CITY OF PORTLAND, MAINE
 DEVELOPMENT REVIEW APPLICATION
 PLANNING DEPARTMENT PROCESSING FORM

2008-0106
 Application I. D. Number

Single Family Home
 Project Name/Description

Randolph St, Portland, Maine

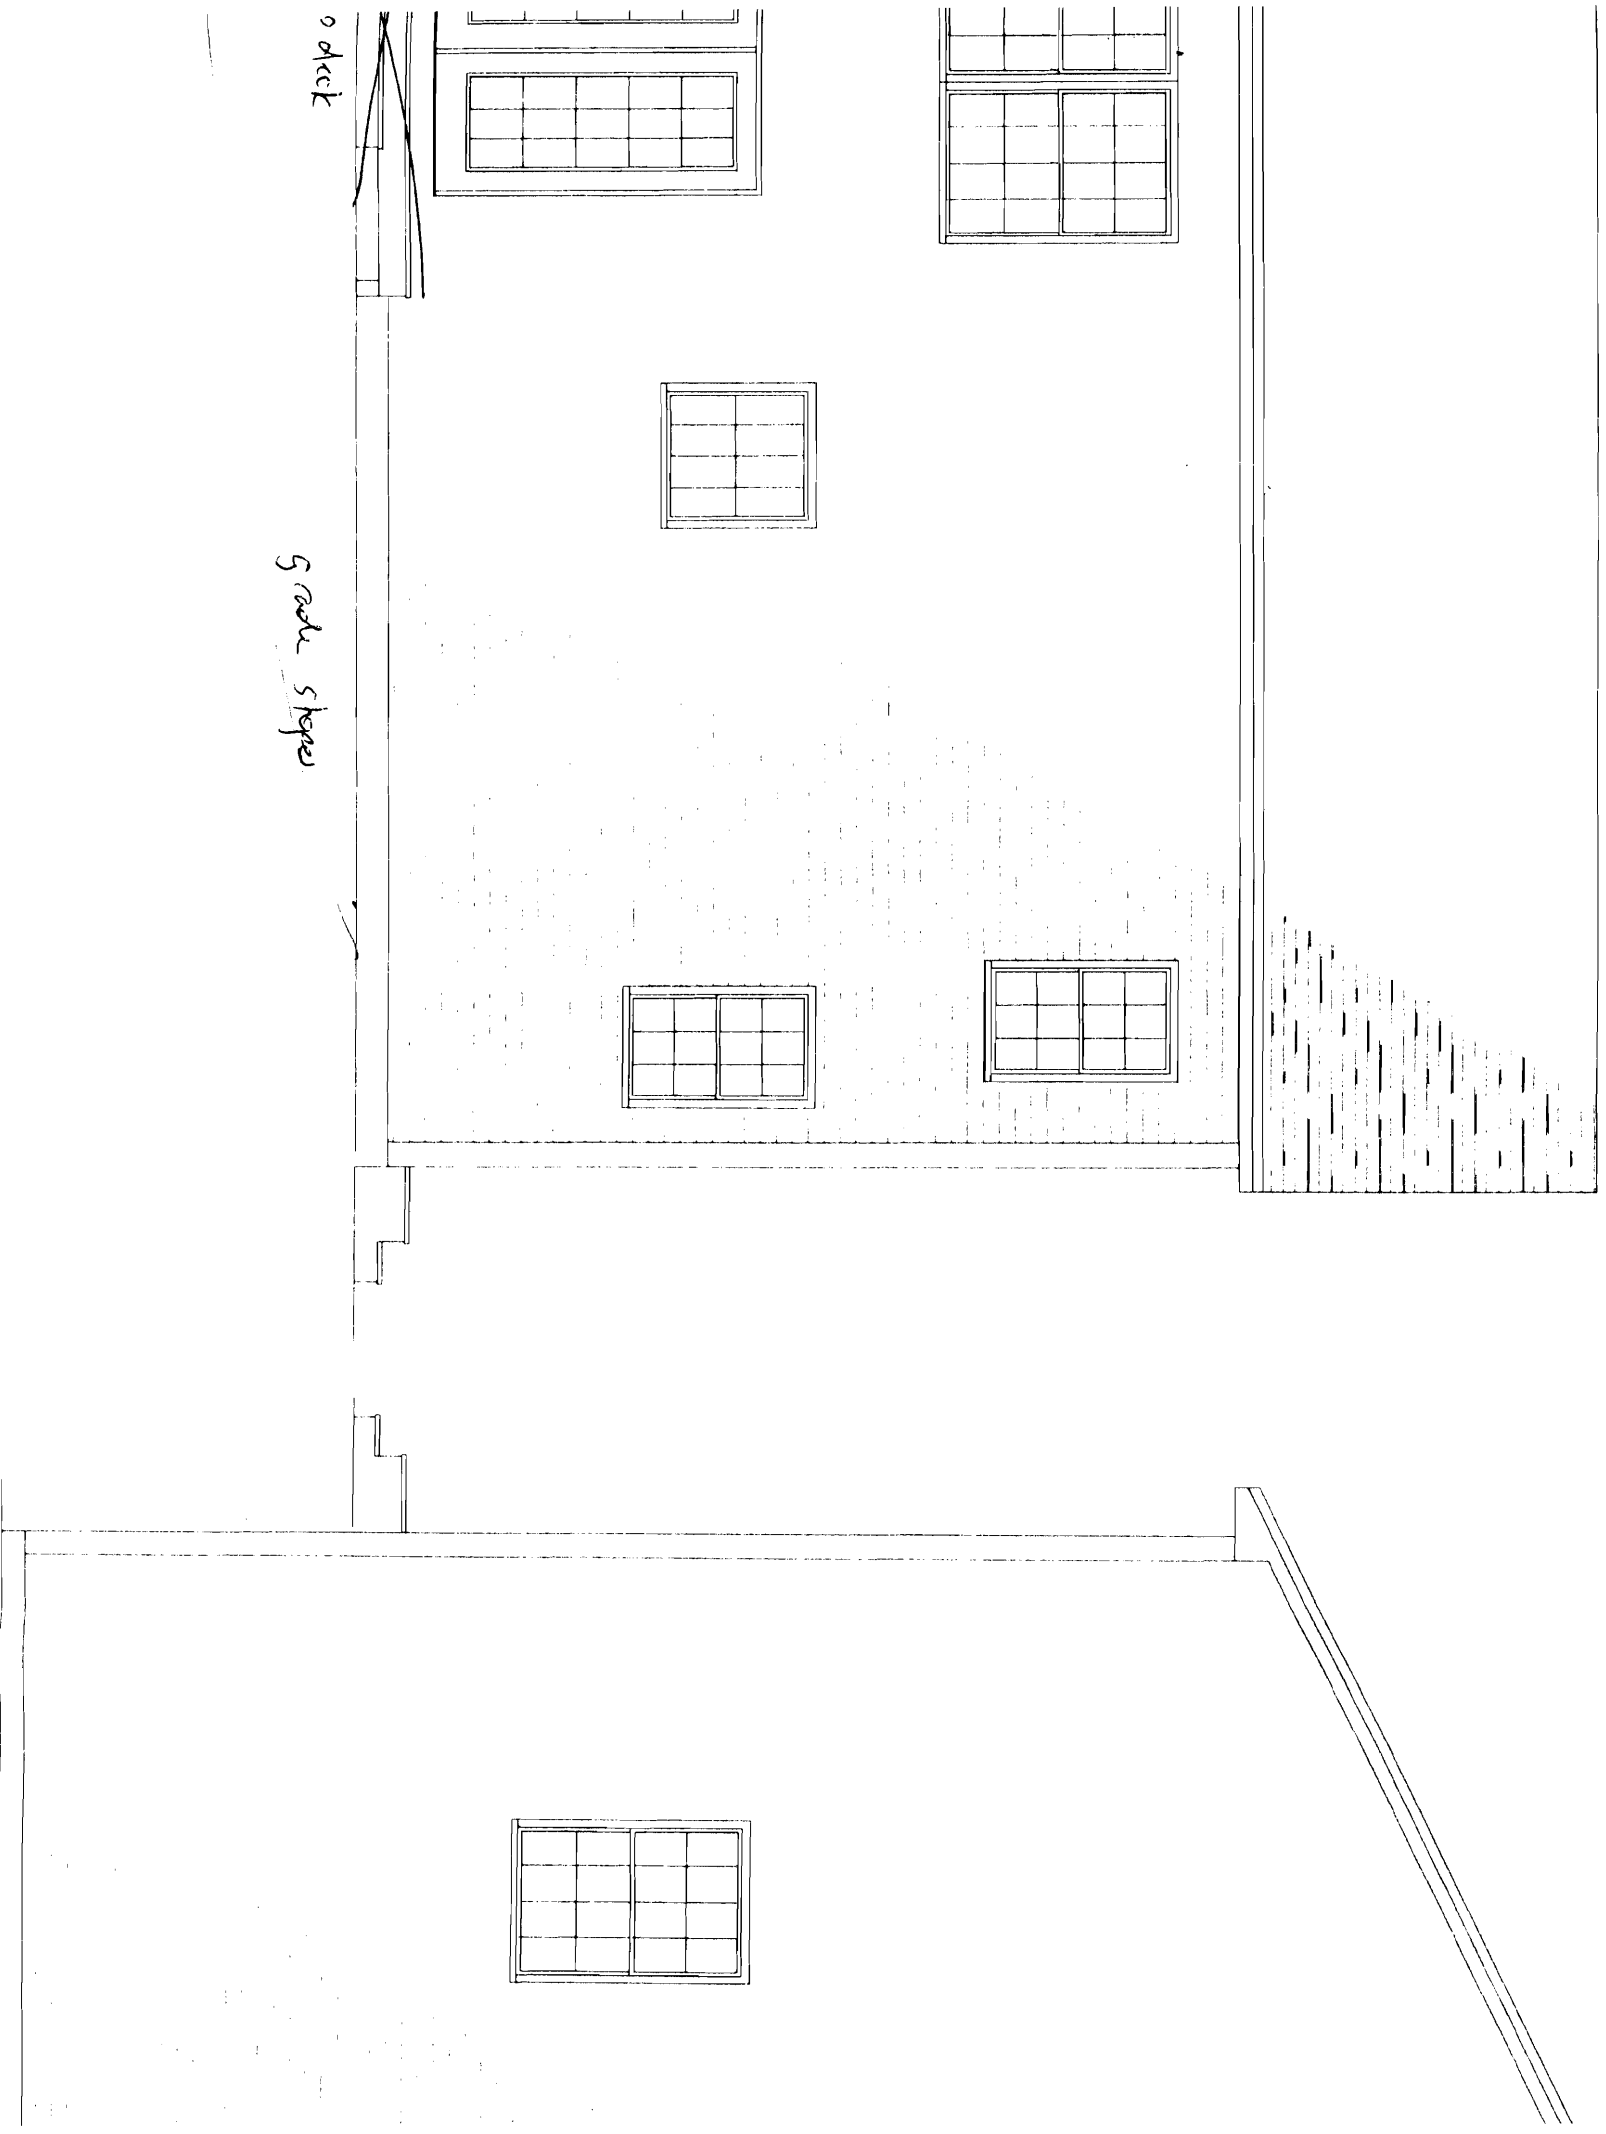
7/11/08
 ✓ Revise Grading plan
 ✓ Too hard to read
 ✓ Contours don't tie in correctly
 ✓ Front Walk/Steps too steep
 ✓ note - over 3:1 slopes to be stabilized w/ Blanket or netting

✓ show electrical utility
 ✓ show 25' stream setback w/ stream
 ✓ 30' Easement?
 ✓ Lot split?

REAR ELEVATION

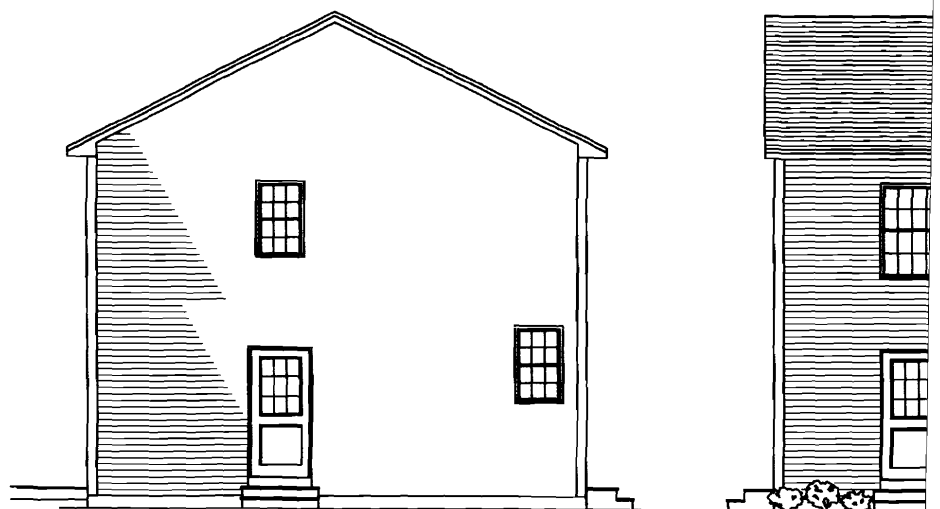
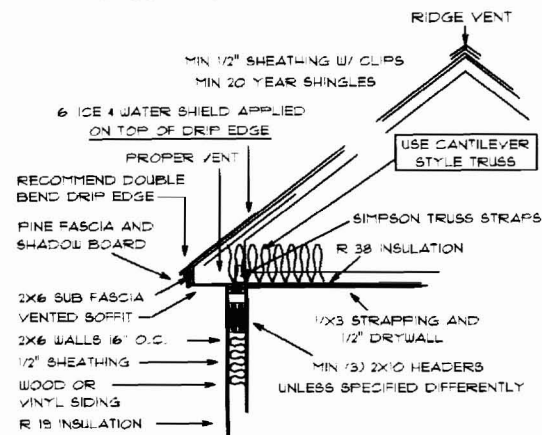
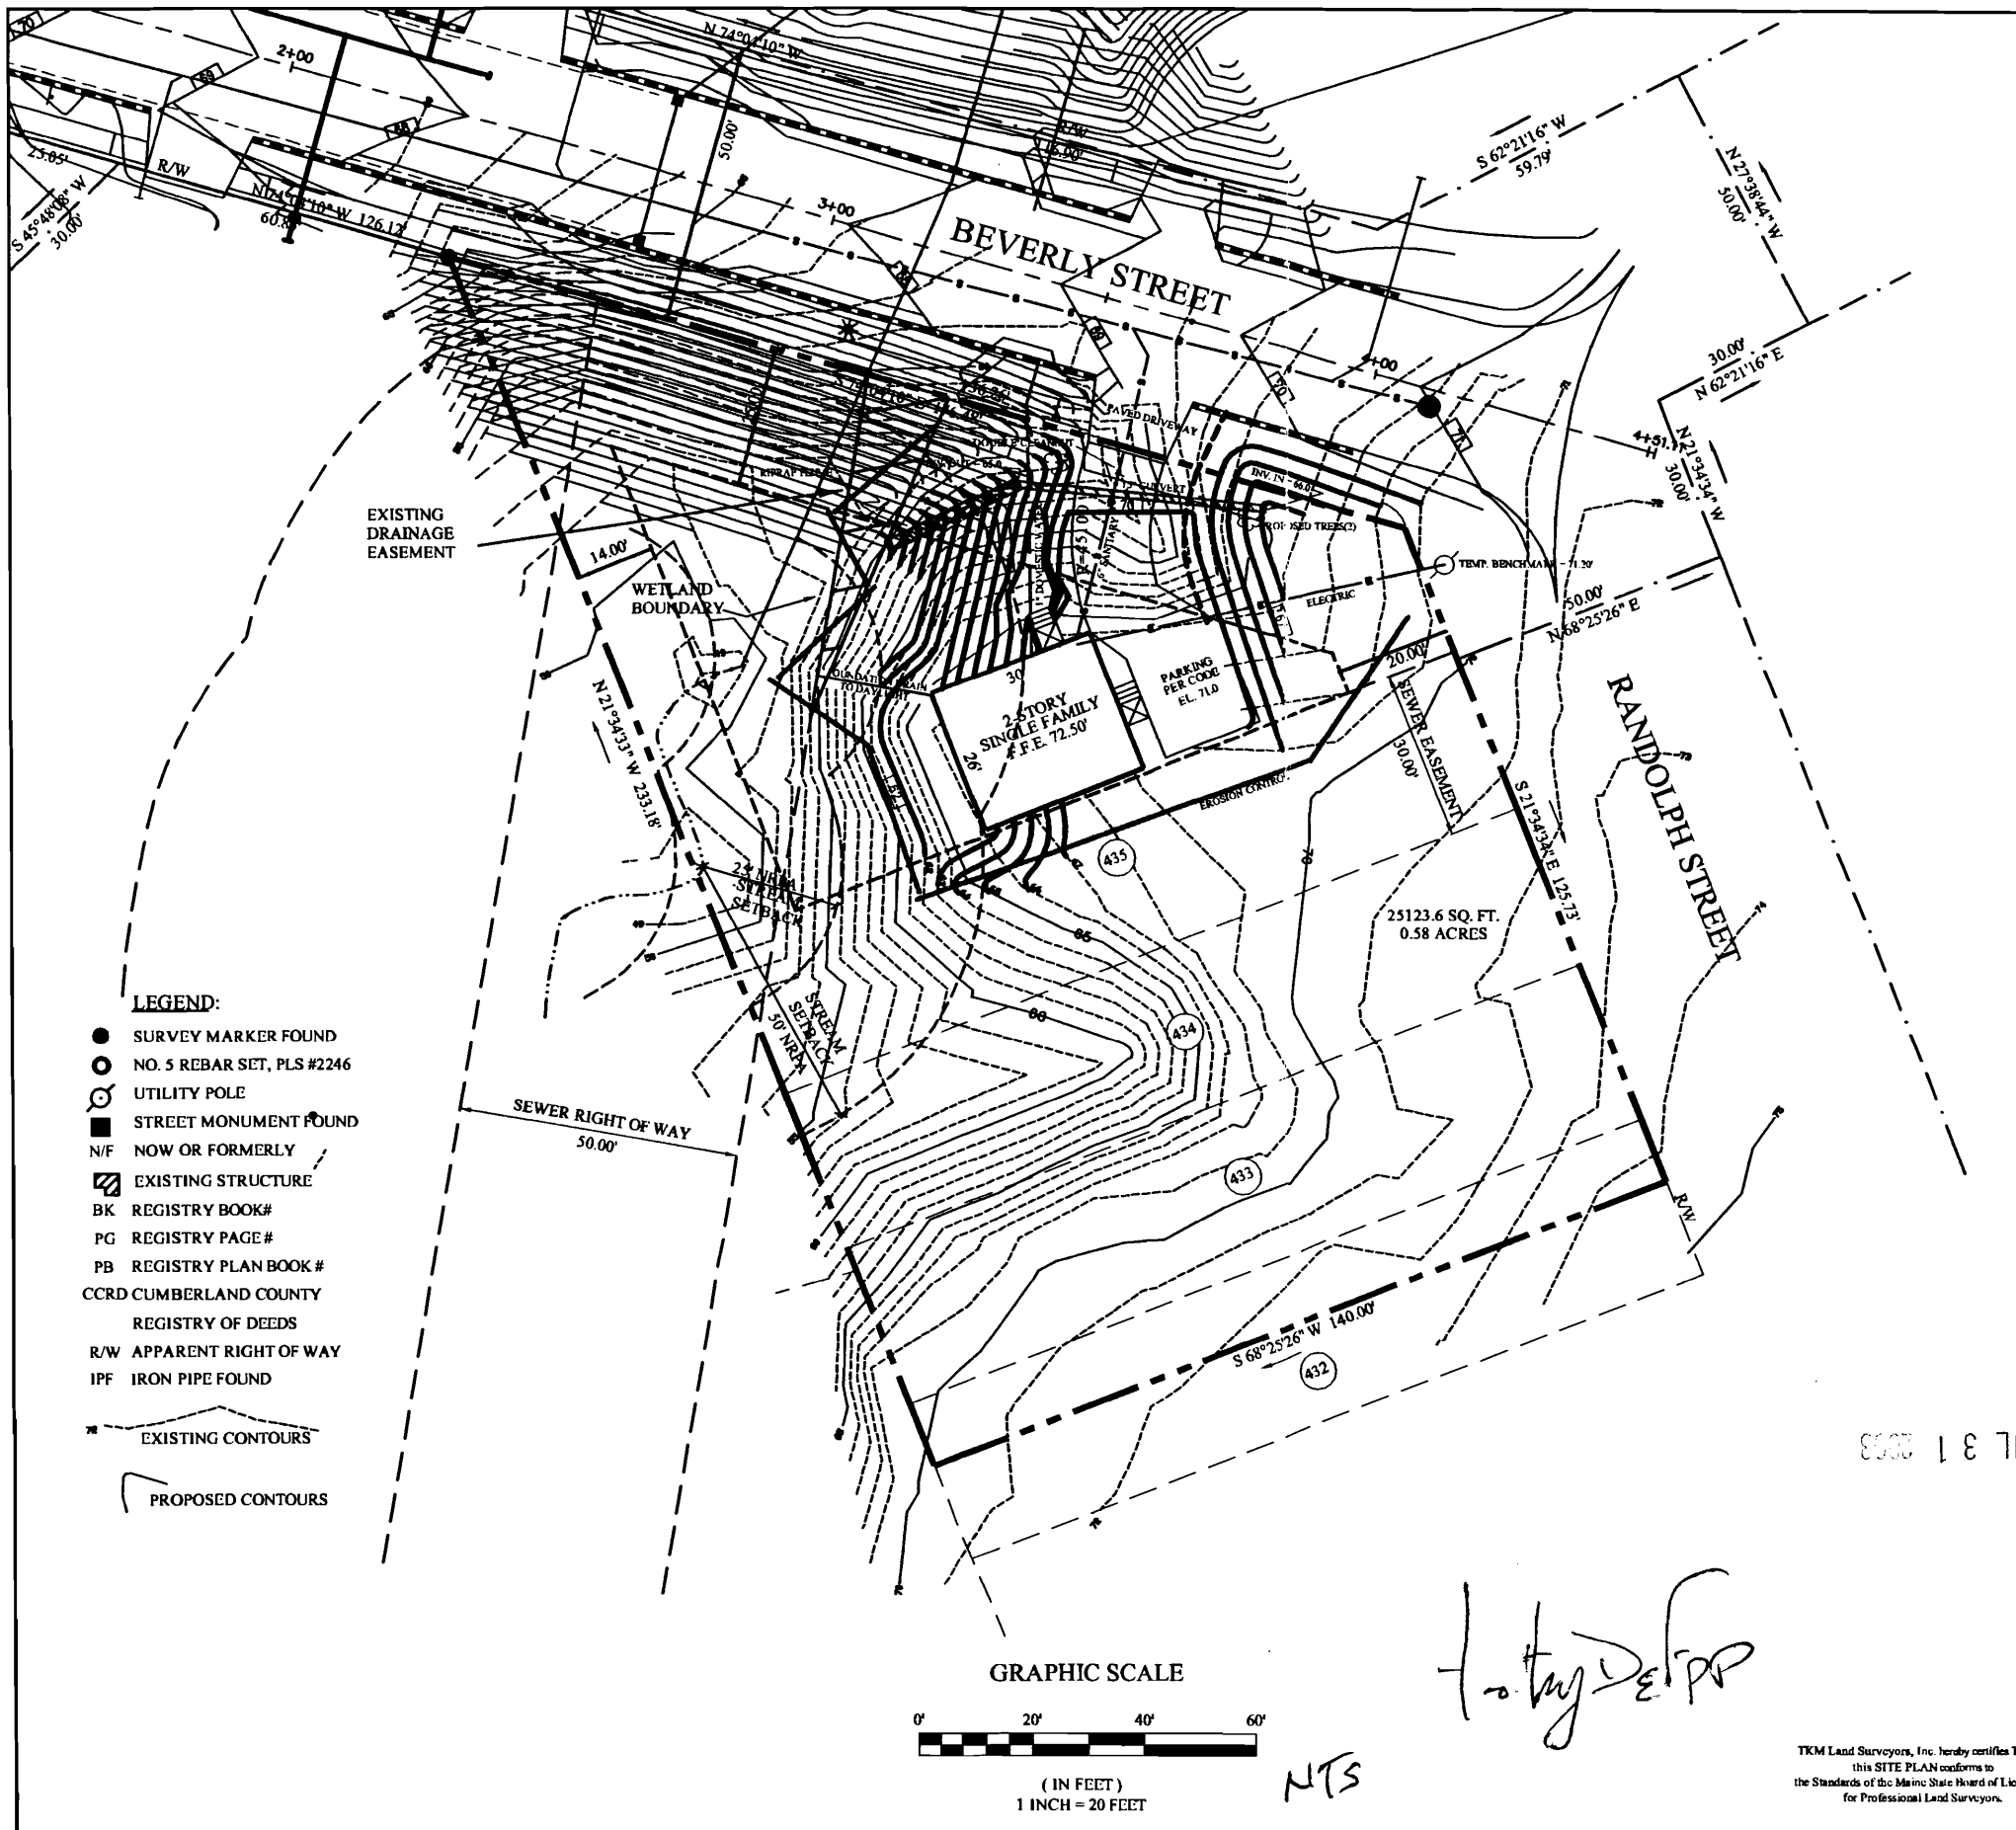
- Grading
- Right elevation
 - Front steps
too steep
 - Front elevation - gradey
 - parking
